ACCESS REPORT PROJECT APPLICATION

JUSTINIAN HOUSE REDEVELOPMENT

19TH OCTOBER 2007

This report has been prepared following a review of the plans to Justinian House at the above location having regard to Part D3, E3.6 and F2.4 of the BCA, referenced standards AS1428 parts 1, 2 and 4 and the accessibility provisions of North Sydney Council's DCP 2002 Sections 9.2, 20.3 and 20.4 (see attached extract).

**LEVEL 2
FLOOR PLAN**
RL.87.70
drawing title

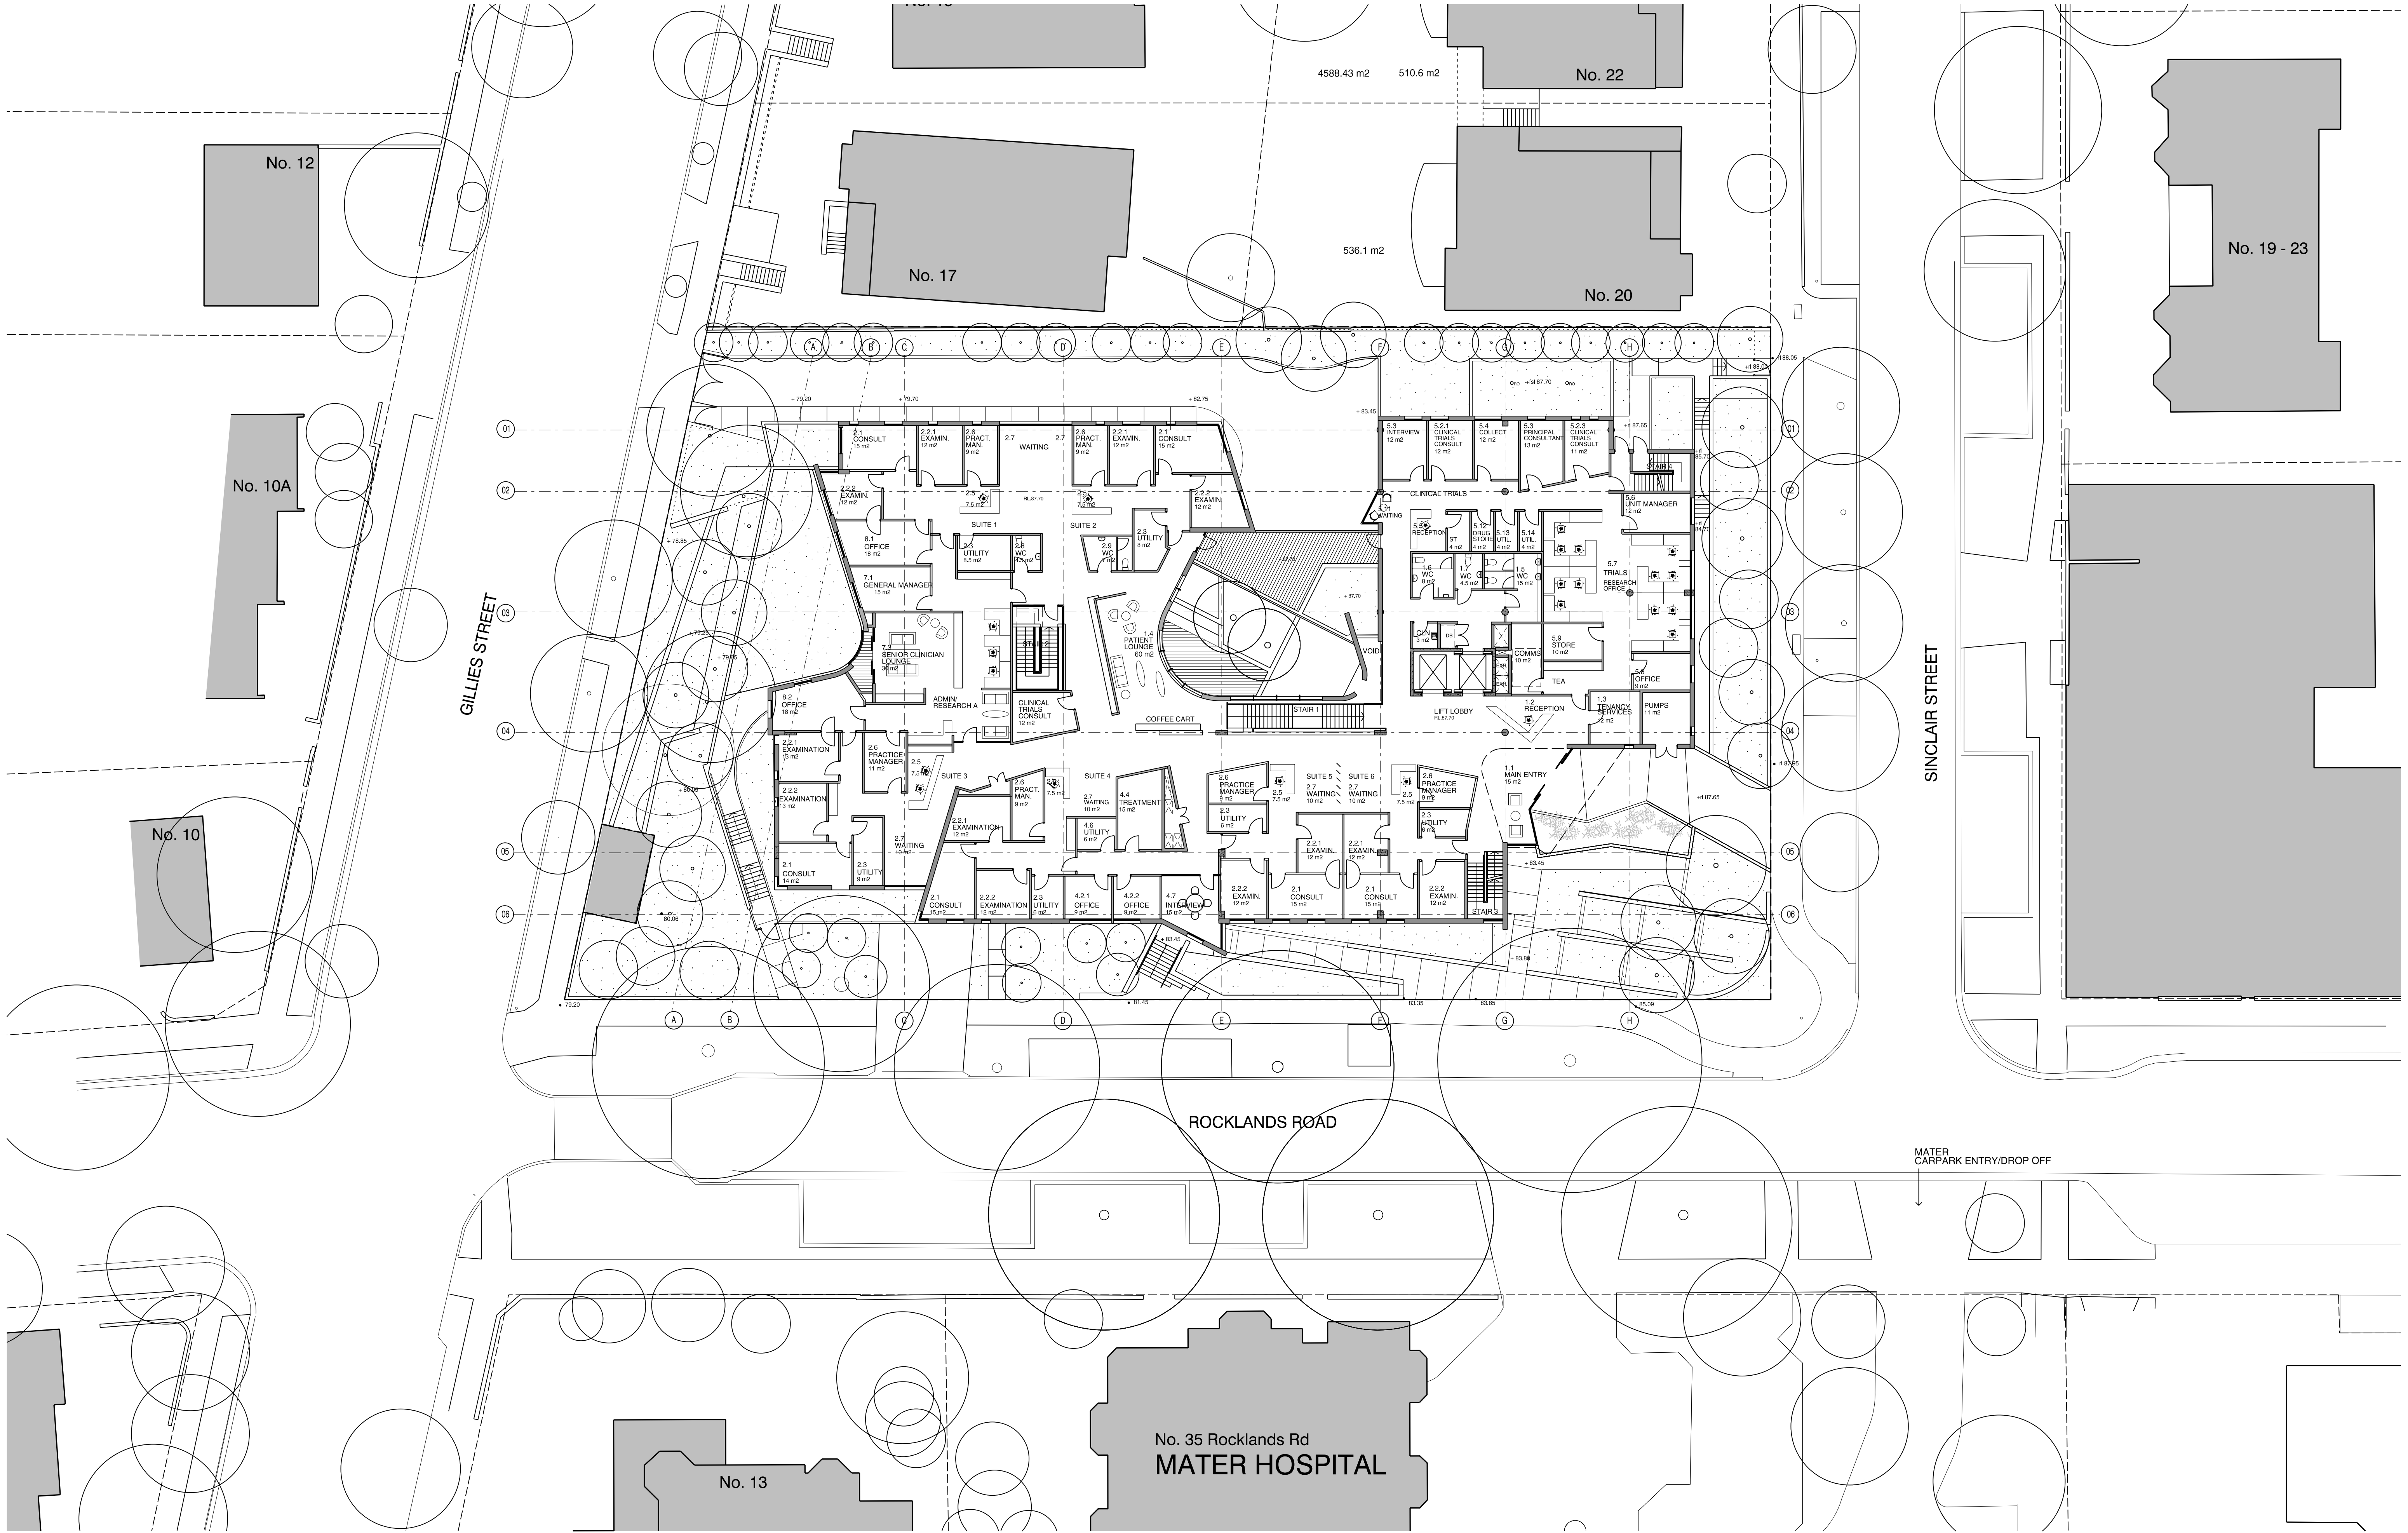
17. Level 2 shall incorporate an on-grade almost level access path from Sinclair Street at approximately RL87.700 to the level 2 reception and lift lobby in accordance with Part D3.2 and D3.3 of the BCA.

18. The level 2 entrance/reception area incorporates 1800mm width primary corridors to facilitate access to the Clinical Trials section, Research Office and various Consultation Suites. The plans indicate appropriate doorway circulation spaces to approach and enter the various offices within the Clinical Trials and Research Office in a manner that will comply with AS1428.2 and Part D3.3 of the BCA. Details of the internal fitout of the reception counter will be confirmed at construction certificate stage to ensure adequate doorway circulation space to the Tea point and Research Office in accordance with AS1428.2 and Part D3.3 of the BCA.

19. **Courtyard Deck** – The plans indicate an outdoor courtyard deck between Clinical Trials and Suite 2 that includes two doorway approaches, and subject to the doorway landing/circulation width adjacent to the Clinical Trials being increased to 1600mm minimum width and 520mm latch side clearance at the doorway with level threshold access then the area will comply with AS1428.2 and Part D3.3 of the BCA.

20. **Patient Lounge and Admin/Research** – The plans illustrate an open plan patient Lounge which provides ample access and circulation spaces. The Admin/Research Office directly adjacent provides three entrance doors that all provide accessible entry subject to the doors adjacent to Stair 1 and Office 8.2 being amended to provide 520mm latch side clearance as required by AS1428.2.

21. **Suites 1 and 2** – Suites 1 and 2 shall be accessible from the main internal corridor and waiting areas and shall provide appropriate doorway circulation space to approach and enter the various rooms in a manner that will comply with AS1428.2 and Part D3.3 of the BCA, except for Consult Room 2.1 which requires a minor relocation of the doorway to ensure 520mm latch side clearance.

23. **Suite 4** – Suite 4 shall be accessible from the main internal corridor and 1500mm width secondary access corridor and shall provide appropriate doorway circulation space to approach and enter the various rooms in a manner that will comply with AS1428.2 and Part D3.3 of the BCA, except for the hallway doorway adjacent to Office 4.2.1/Utility 2.3 which requires a minor relocation of the doorway to ensure 520mm latch side clearance.

25. **Stair** – The stairway adjacent to the entry foyer linking the level 2 and level 3 areas shall be detailed at construction certificate stage to include tactile indicators and handrails on both sides consistent with AS1428.1.
